July 2, 2020

Re: Mesa del Sol Montage Unit 4 (Project # PR-2020-003422, Application # SD-2020-00091,
Hydrology File R16D006A), Comment Response Letter

# PRELIMINARY PLAT OF MESA DEL SOL MONTAGE UNIT 4

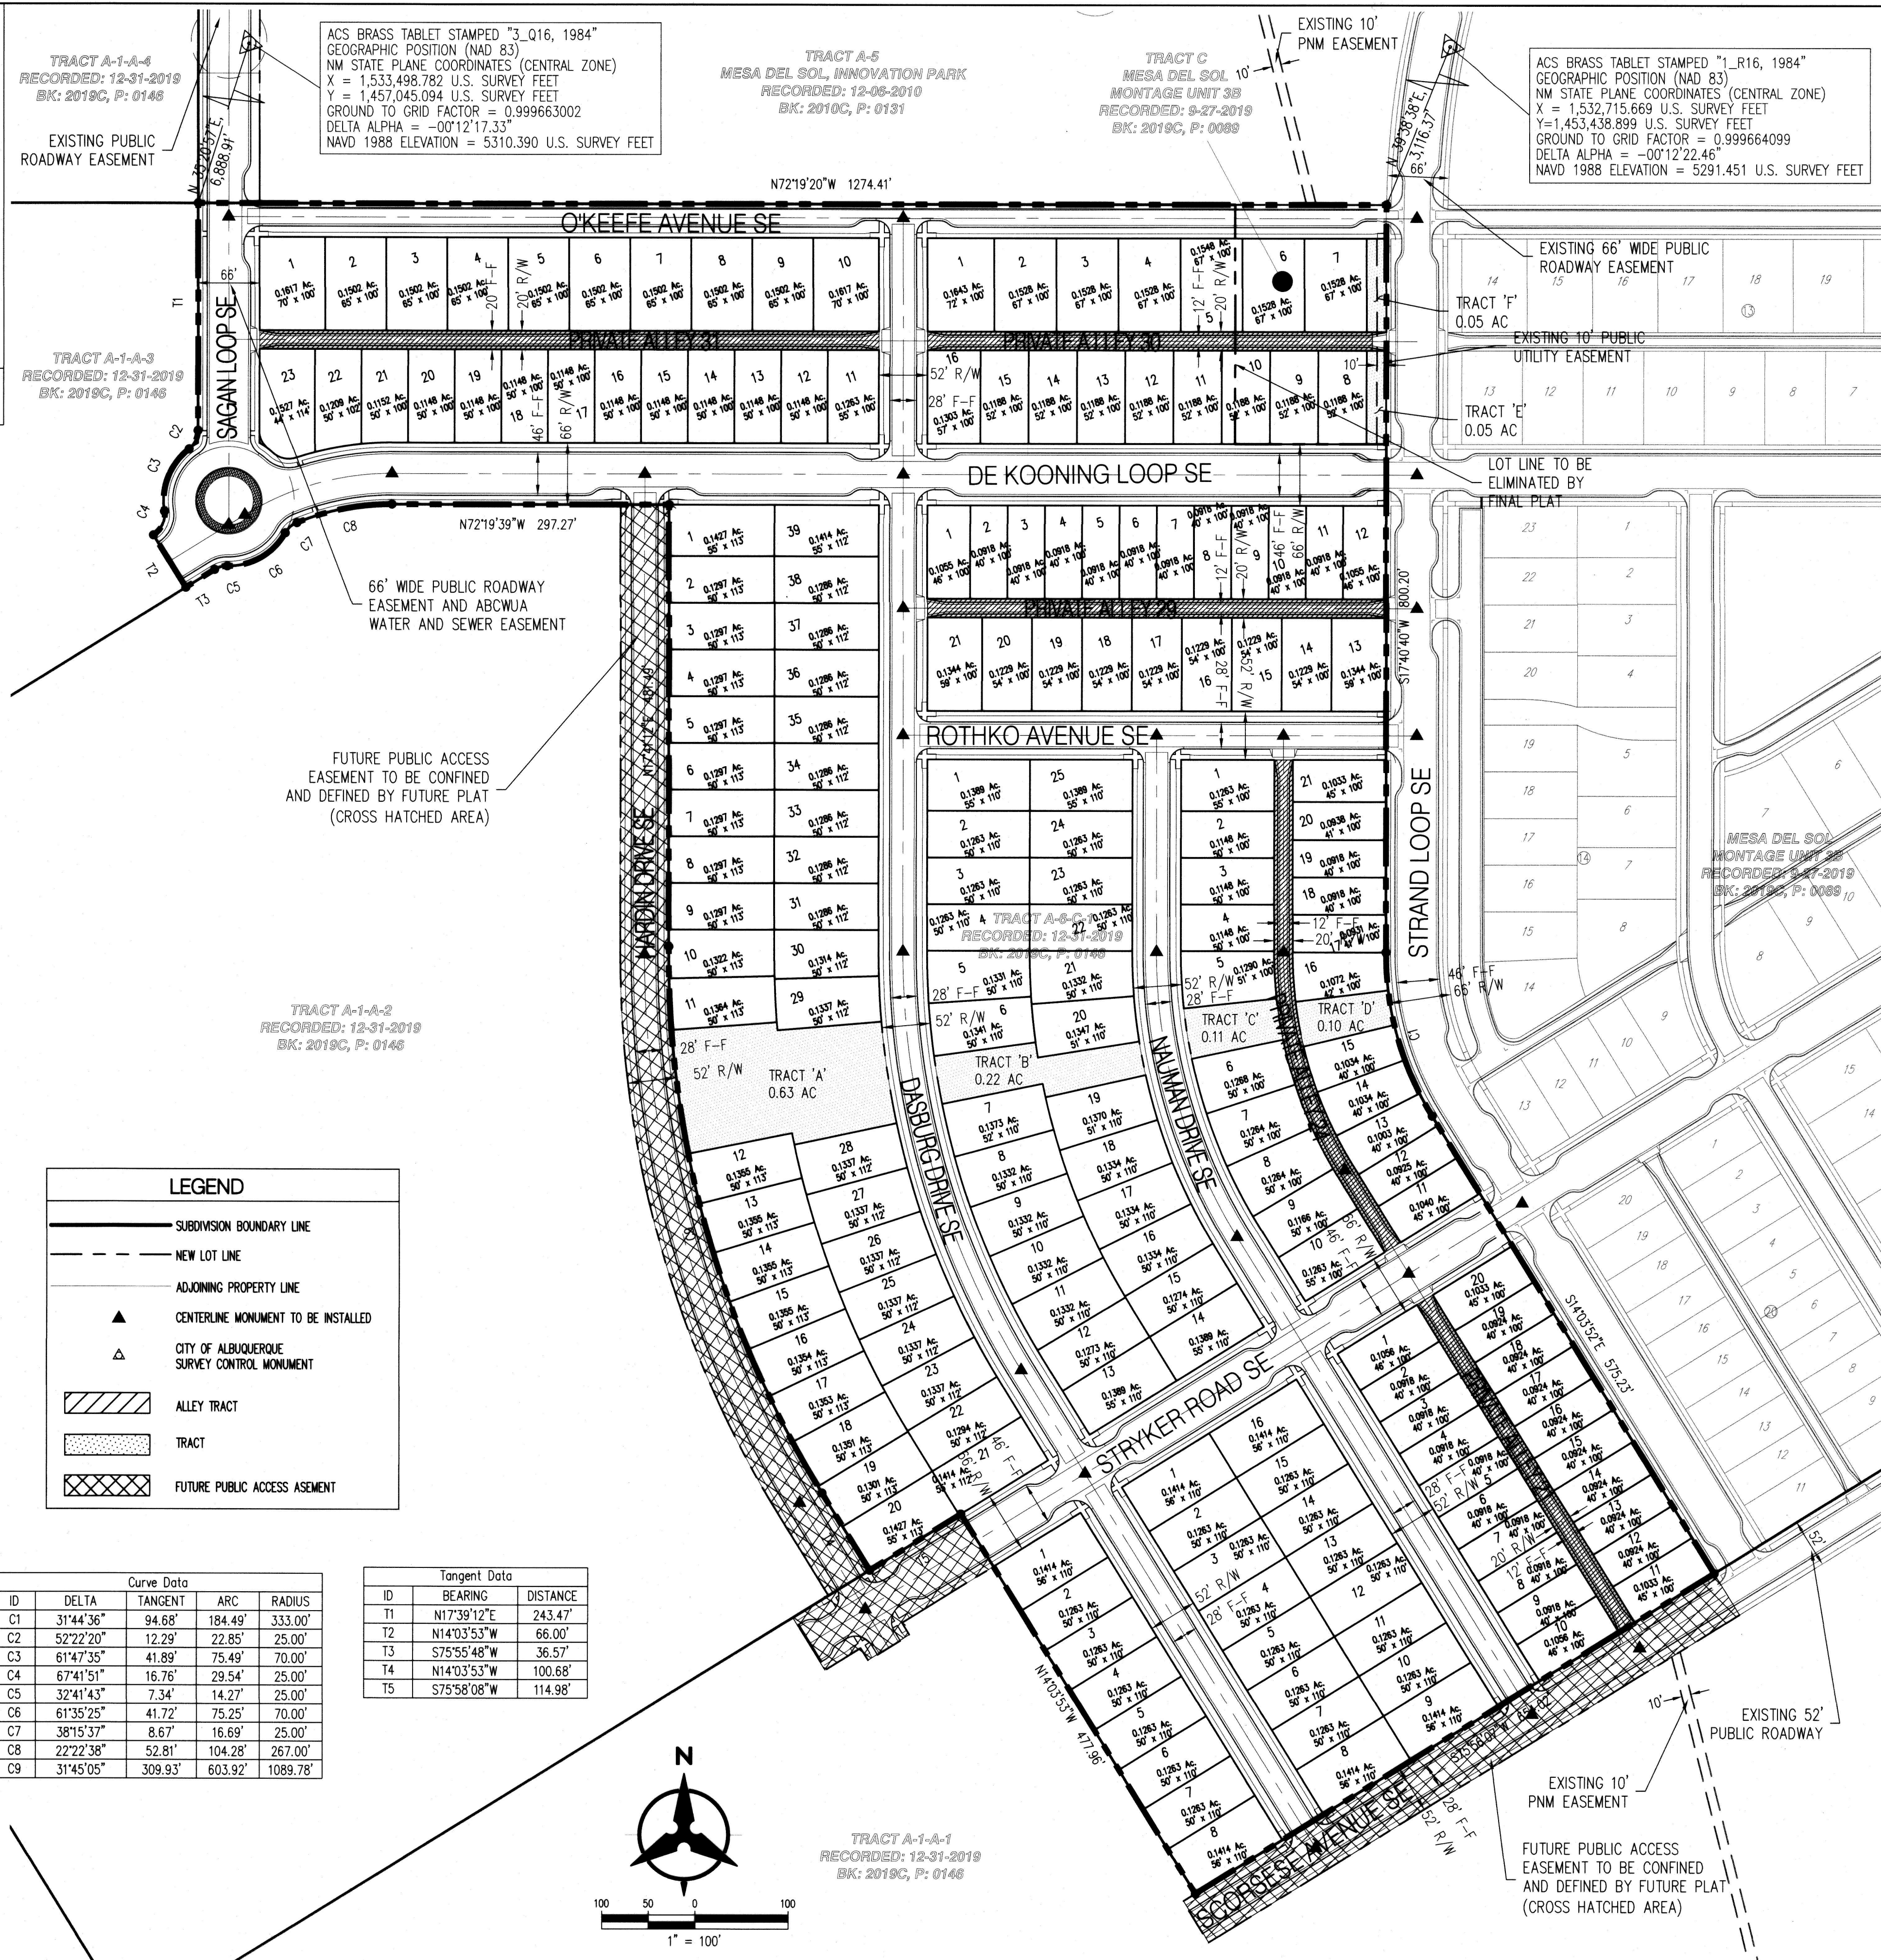
1. Street layout must be consistent with the Mesa del Sol level B Masterplan, see section 3.1. A recorded infrastructure improvements agreement will be required prior to final plat sign off Future development must be consistent with the Mesa del Sol level B Master plan.

Response: The plan is consistent with the Level B Master Plan. Please See attached Preliminary Plat, and Revised Infrastructure List
